Our Ref: A/184/17/PL

**Town & Country Planning Act 1990 (as amended)
Town and Country Planning (Development Management Procedure) (England) Order 2015
Application for Full Planning Permission**

Development Change of use from light industrial (B1Business) to leisure (D2 Assembly & Leisure).
This application may affect the character & appearance of the Angmering
Conservation Area.

Location Seymour and Lisle Ltd The Square Angmering

Drawing
Location Plan

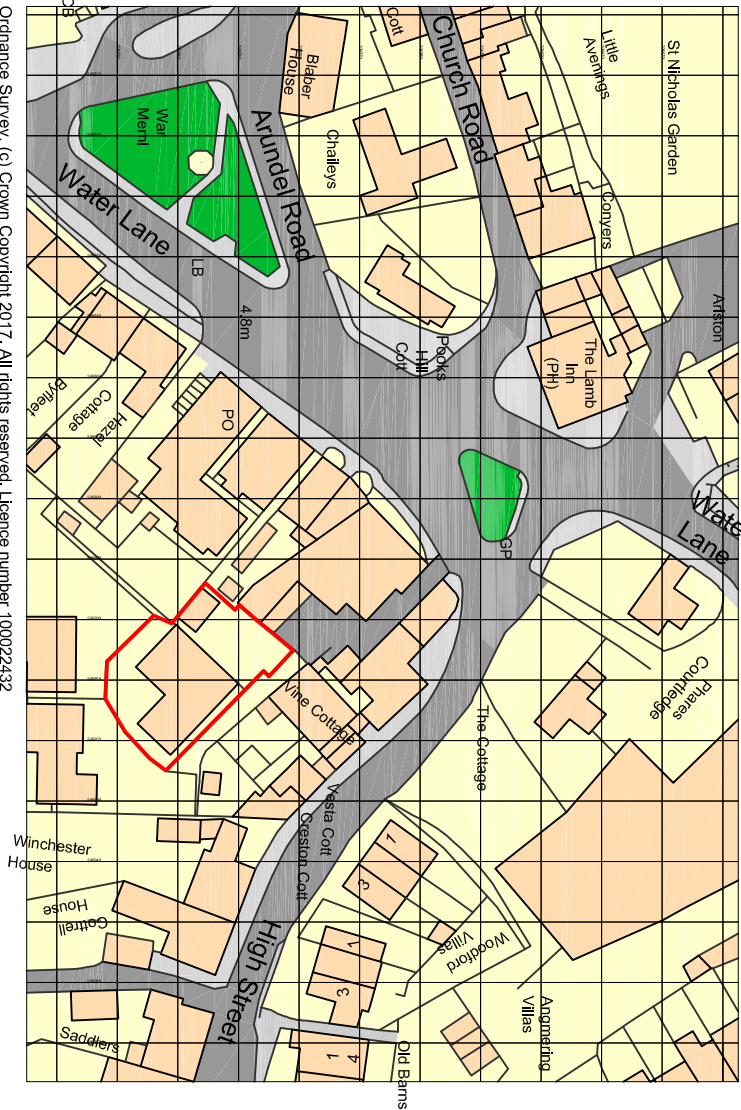
The red edge on the location plan and block plan differ. Please ensure that the red edges on both of these plans match and return accordingly.
